Our ref:AN/SL/CF0018

Non-Material Amendment of Condition 19 'Materials and Finishes' of Planning Condition Discharge 18/00039/DISC and Planning Permission 10/01780/HYBRID

Following the approval of Planning Condition 19 'Materials and Finishes' on 25th April 2019, Elmsbrook LLP are seeking to amend this condition by superseding the approved facing brick 'Freshfield Lane Rural Multi' with 'Crest Cardinal Red Multi'.

# Cardinal Red Multi

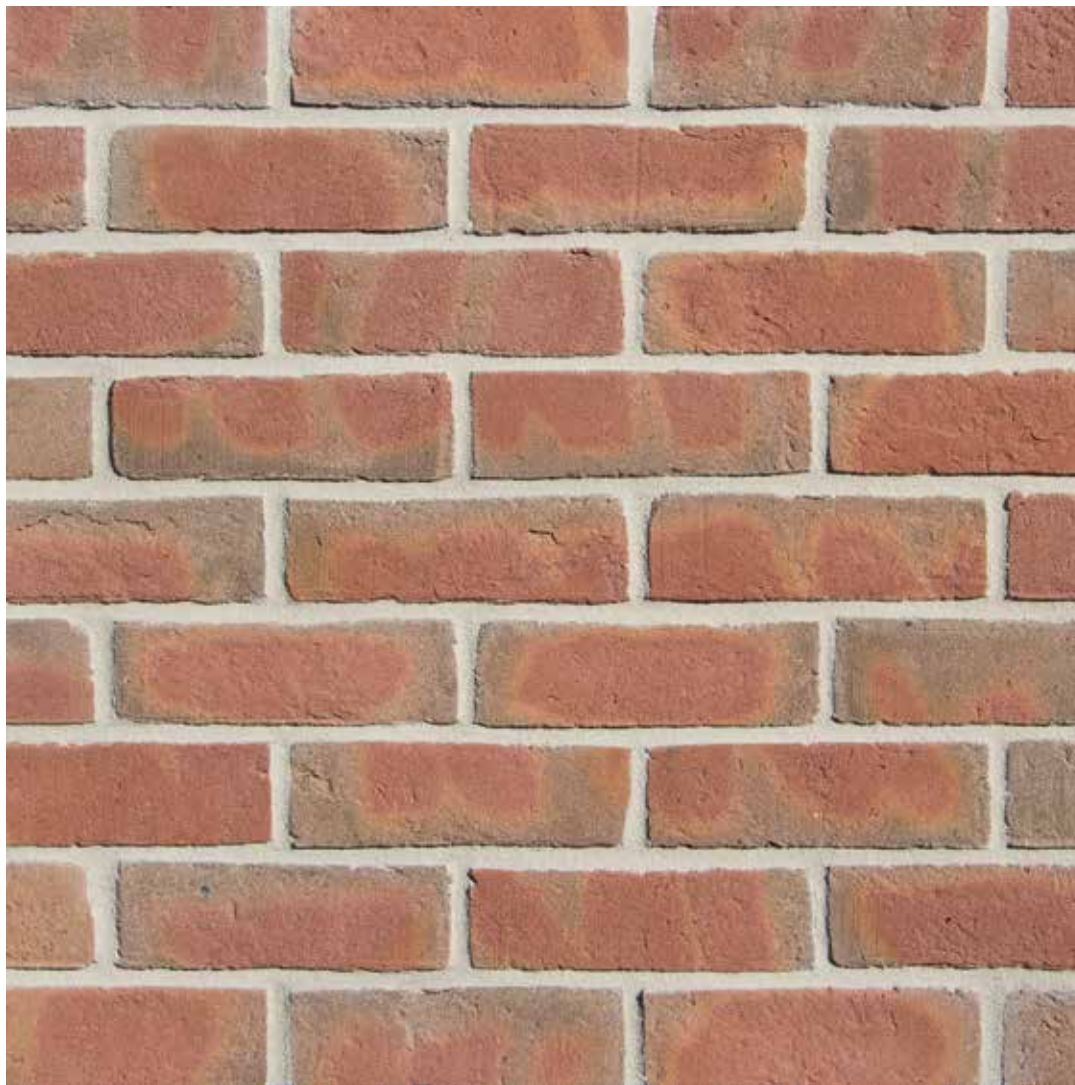
It is our intention to carry on building the remainder of Phase 3 at Elmsbrook in the approved 'Freshfield Lane Rural Multi'. However, on Phase 4, we are proposing the new brick 'Crest Cardinal Red Multi'. Because Phase 4 is separated by open space and a hedgerow from Phase 3, any minor differences in colour or complexion will not be noticeable as they will not be standing side by side.
